**Consultation Response from Mark Berry KC,
Highways Development Management**

2022/93679 Field House, 15 Wellington Street, Dewsbury, WF13 1BQ

Discharge condition 10 (CMP) on previous permission 2019/92962 for erection of additional storey and conversion of building to provide 23 self-contained apartments and A3 use in basement and part of ground floor (Listed Building within a Conservation Area)

Date Responded: 27-11-2023.

Site Setup Plan:

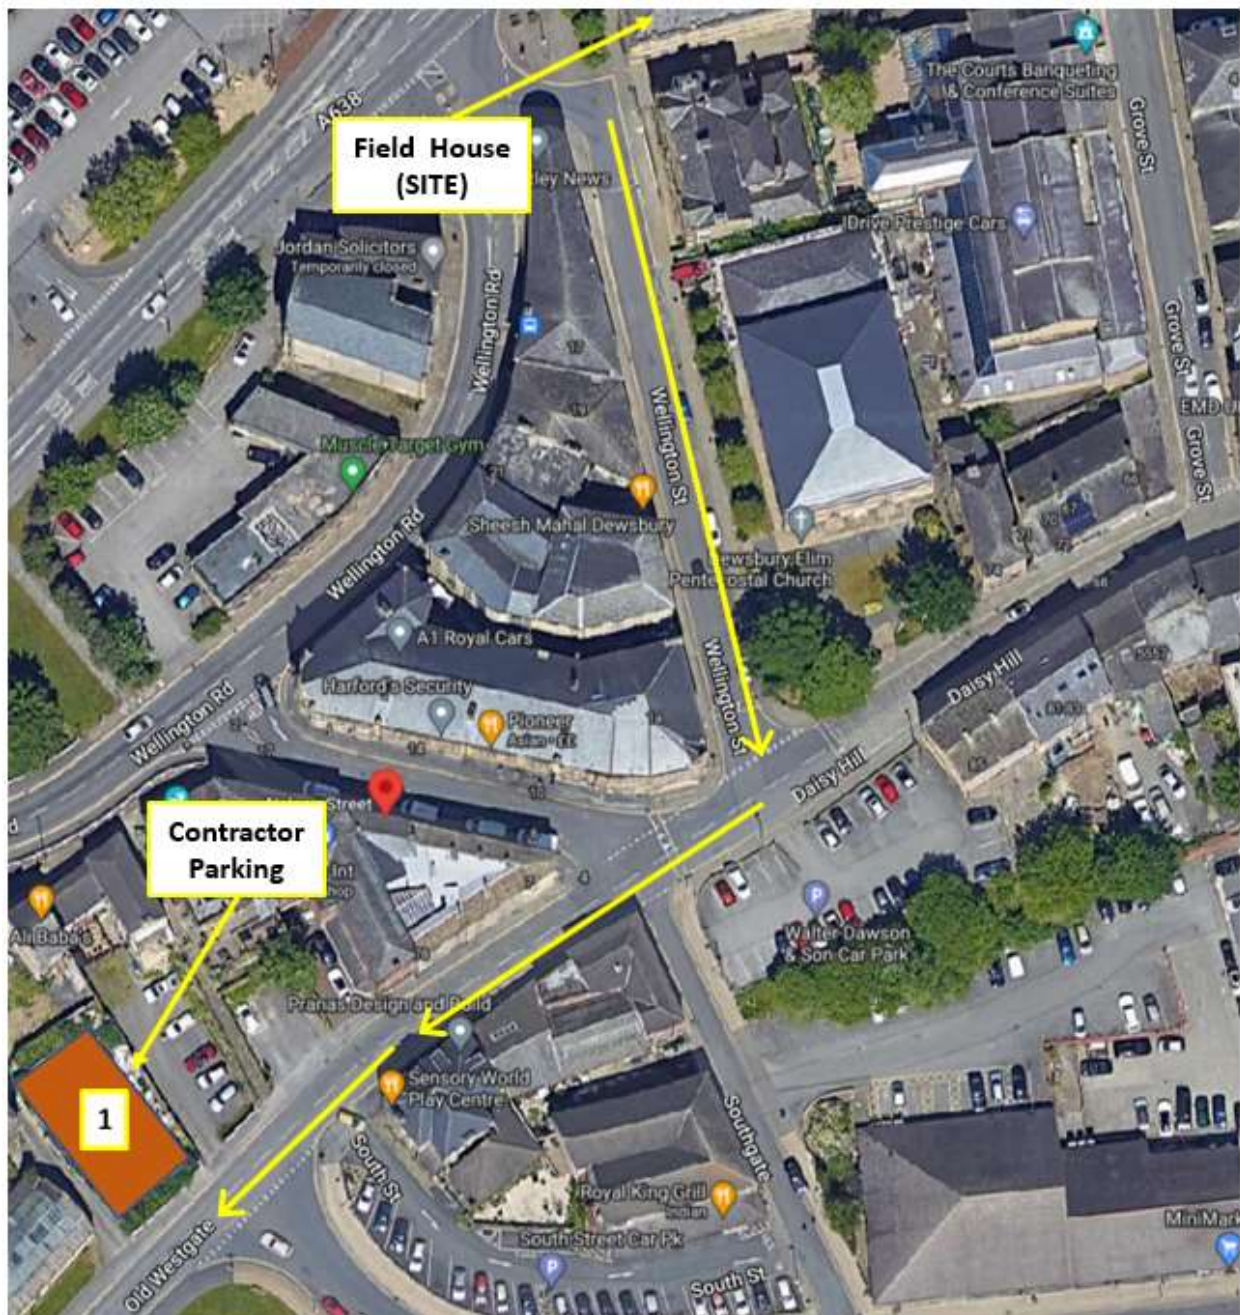
1, The proposals include providing scaffolding on or over the adopted highway and the temporary closure of parts of the adopted highway which will require the separate formal approval by the Councils Highway Service. The discharge of this condition does not imply approval to the temporary closure of any adopted highway.

2, Can the applicants confirm the residual width of footway that will be available to pedestrian around the perimeter of the site when fencing and scaffolding are erected, and the works are ongoing.
